I write to object to the planning application AL/81/21/PL-Ryefields Farmhouse, Woodgate.

I wish to take this opportunity to raise questions regarding the Transport Technical Note accompanying the planning application as this appears to be incorrect on several points which I believe effect the current application as submitted.

Figure 1.3: Proposed Site Layout

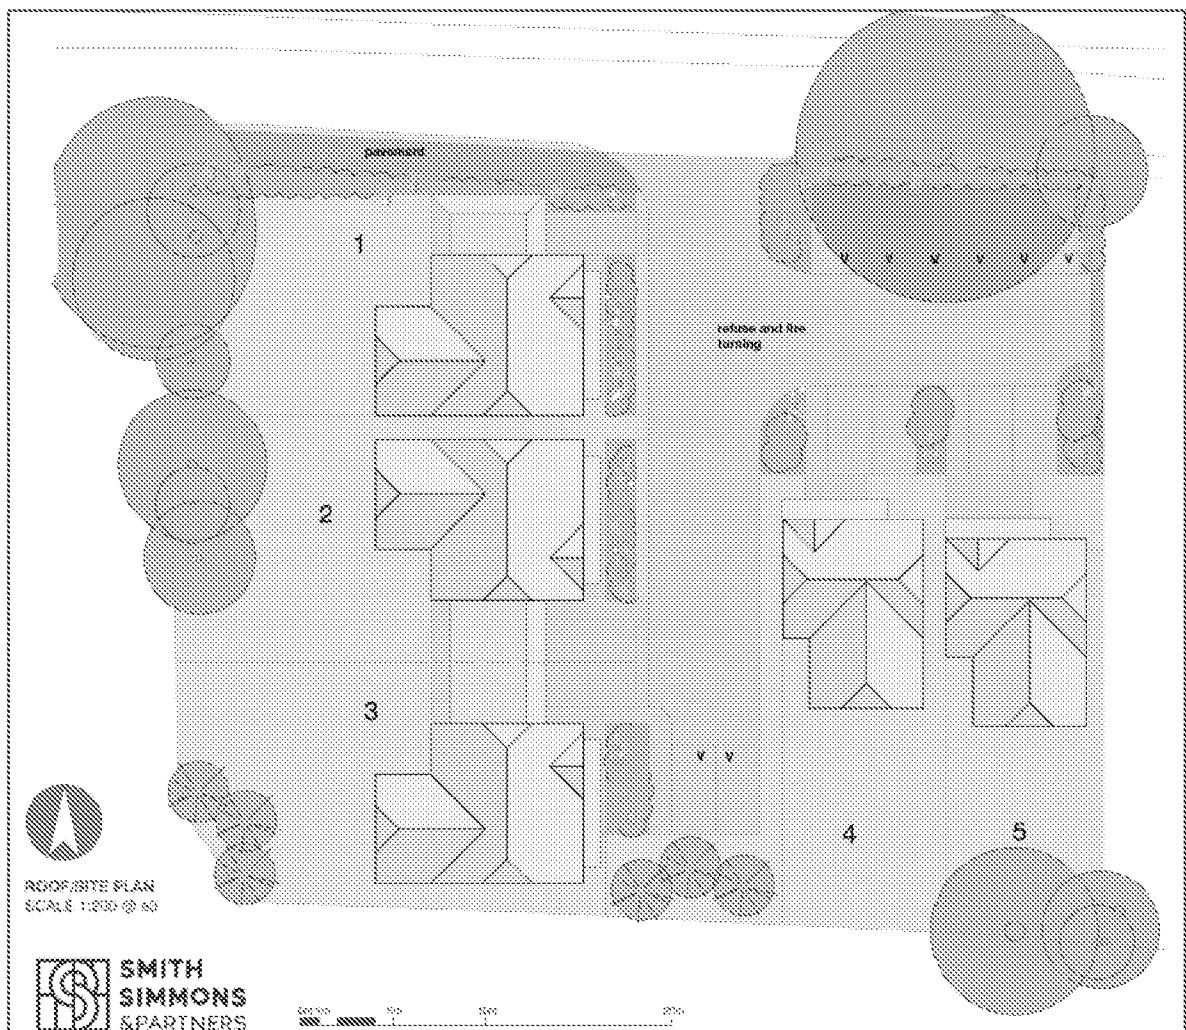
2. Page 3 Item 1.14 states "...a 2m wide footway along the western frontage of the site..."
Page 5 Item 1.31 states "....2m wide footpath along the western section..."

From the submitted plans at page 3, page 6 and the roof site plan the proposed 'pavement' is shown on the northern side of the proposed development site. I do not understand how the Developer can state the footway is on the Western Frontage of the site? It is not easy to understand how such a simple mistake of West and North could occur? The previous application was refused, one of the points of refusal being the lack of a continuous suitable footpath and the lack of accessibility to all users, especially the needs of vulnerable users'. This specific point was highlighted by both the ARUN Planning Officer and the Planning Inspector (Appeal Decision APP/C3810/W/193243619 and AL/72/19/PL.

PROPOSED STREET ELEVATION
SCALE 1:200 @ a3

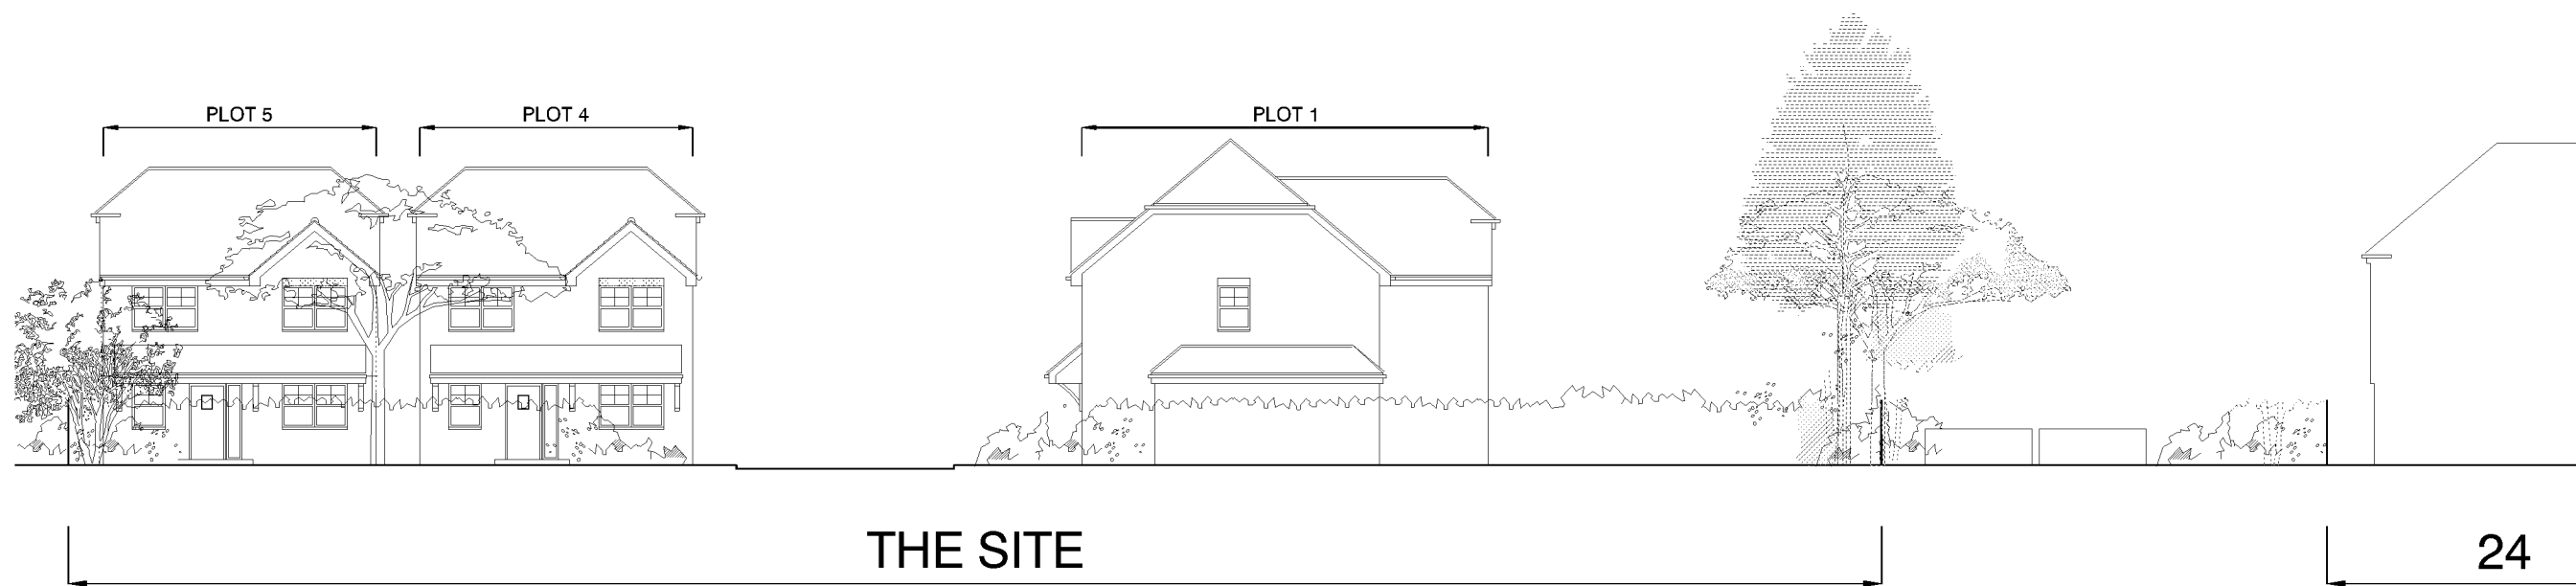
4. The design of the houses for the potential development site, is at odds with the current street scene. The previous application (AL/72/19/PL) went almost overboard in their literature, if not the actual house designs, to impress that their development would be an extension of the existing Oak Tree Lane estate. This application would appear to take the stance that the current street 'scene' is irrelevant. The proposed dwellings would appear to be different in shape and certainly in the choice of external materials i.e. tile hung exterior walls.
